**KIRKLEES METROPOLITAN COUNCIL
INVESTMENT & REGENERATION SERVICE**

Reference No: 2025/61/92242/W

Site Address: Land off, Hermitage Park, Lepton, Huddersfield, HD8 0JU

Description: Reserved Matters application (including consideration of appearance, scale and landscaping) for the erection of 80 dwellings, pursuant to Section 73 approval 2025/90105 pursuant to previous outline permission 2022/91735, and the discharge of outline conditions 6, 7, 8, and 9

422 / DENSTONE (PLOTS 43, 46, 75 & 76) PLANS & ELEVATIONS

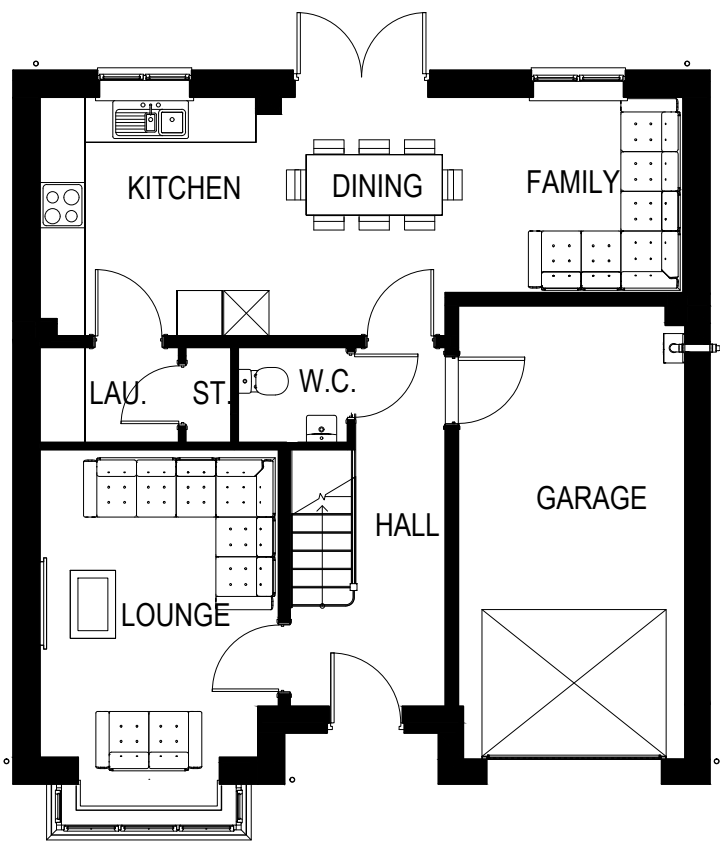
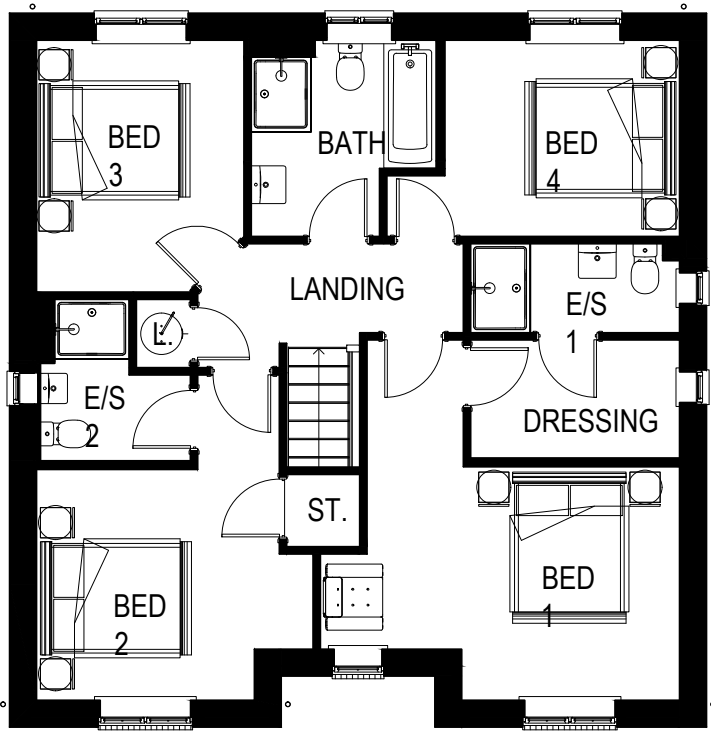
The West Yorkshire Police Designing Out Crime Officer (WYP DOCO) expressed concern that the designs of the Gr(a/e)yford, Denford, Cherrystone and Denstone house types would create opportunities for crime, and requested redesigns or lighting and CCTV to address these concerns. Rather than amend the designs (which, it is accepted, would reduce the relief to, and visual interest of, the front elevations of these dwellings), the applicant has submitted a document titled "Woodsome View, Lepton – External Lighting" (Miller Homes, October 2025). This includes product information for the external luminaires the applicant intends to install adjacent to the front doors of the dwellings. These are considered acceptable in design terms, and would help to address the crime concerns raised by the WYP DOCO.

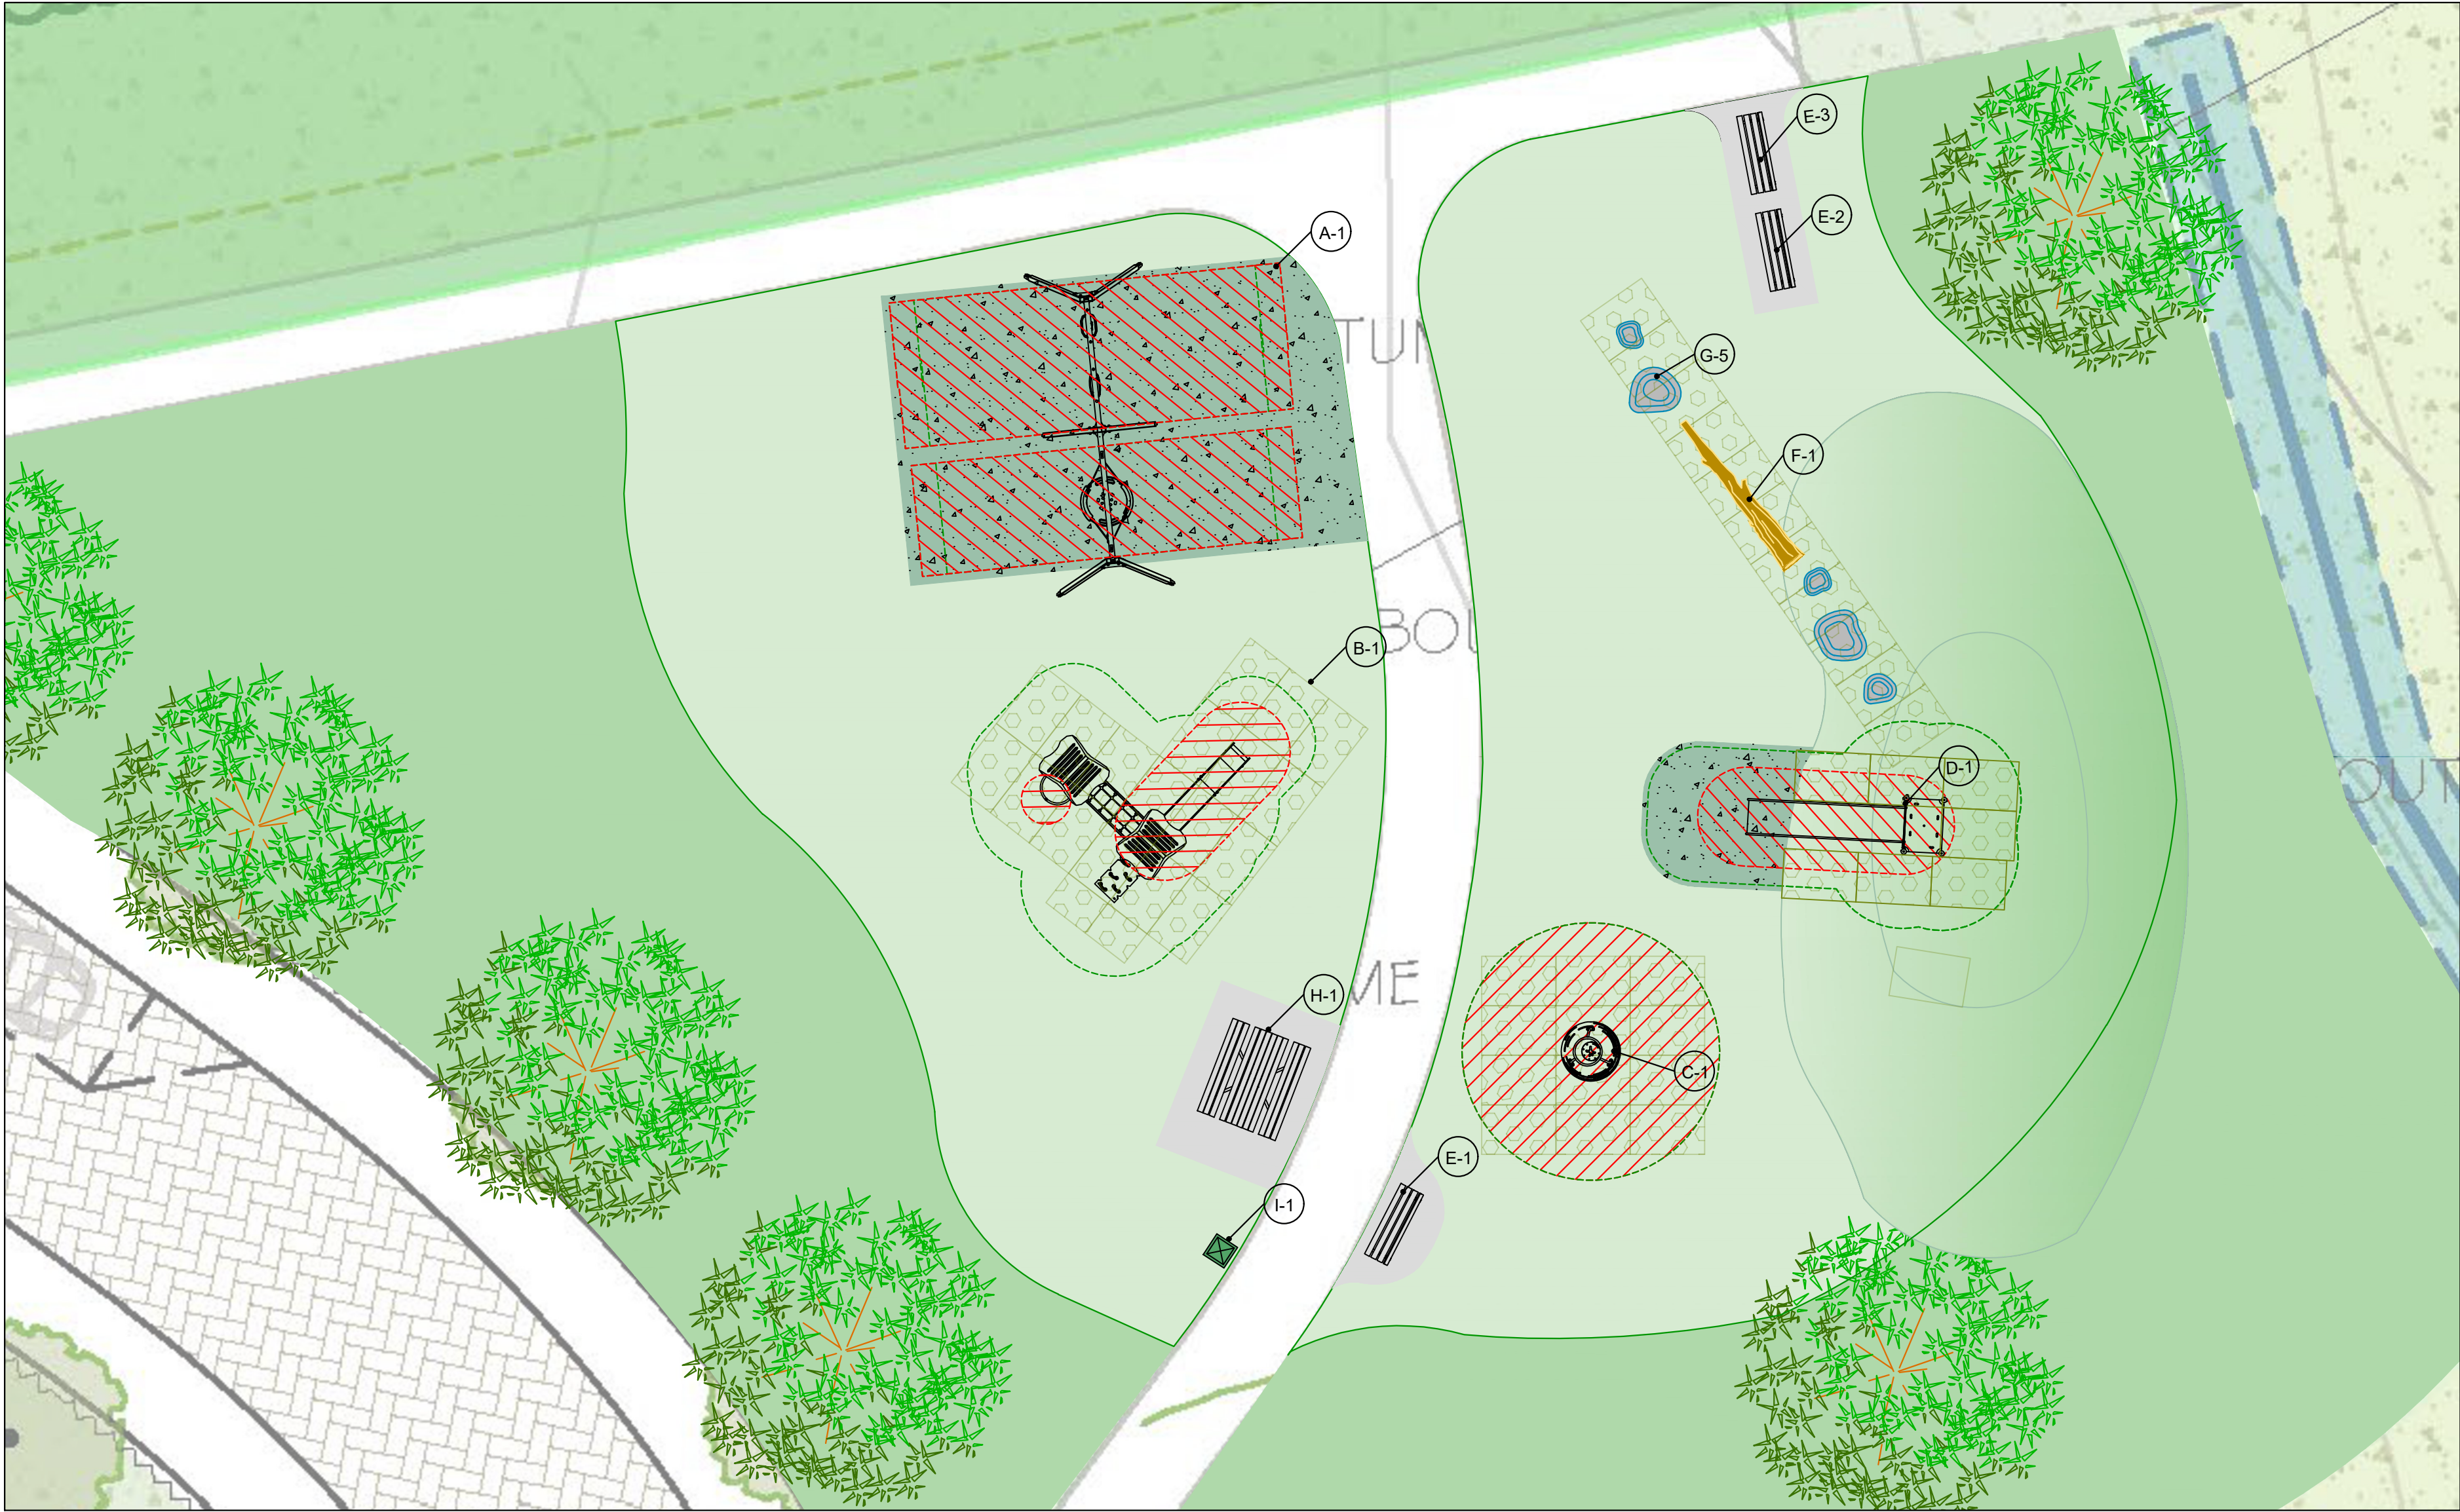
- Native, thorny hedgerows along the ancient woodland boundary – Temporary protective fencing/chespale fencing would aid establishment.
- On-site open space – KC Landscape saw a detailed play areas plan (from Victoria Wilkinson of Kompan) in March. This should be included in the submission (along with details of litter bins etc), and referred to in the LMP (which should also cover bin emptying etc). The submitted public open space typologies plan incorrectly suggest that there is currently to council requirement re: outdoor sports.

Various submissions were made by the applicant team in response to the above requests, to other requests made at meetings, and to consultee responses. Most recently, on 29, 30 and 31/10/2025 and 03/11/2025 the applicant team submitted various drawings and documents to address consultee comments. On 04/11/2025 a complete suite of house type drawings (40 in number, including resubmissions of drawings that did not need amending) was submitted, showing heads and cills to the front, side and rear elevations of all dwellings. On 05/11/2025 a further eight revised plans were submitted, as was a revised Landscape Management Plan. On 07/11/2025 the applicant team confirmed that a "rev B" version of a drawing relating to the proposed Local Equipped Area of Play should be considered (instead of the submitted rev A).
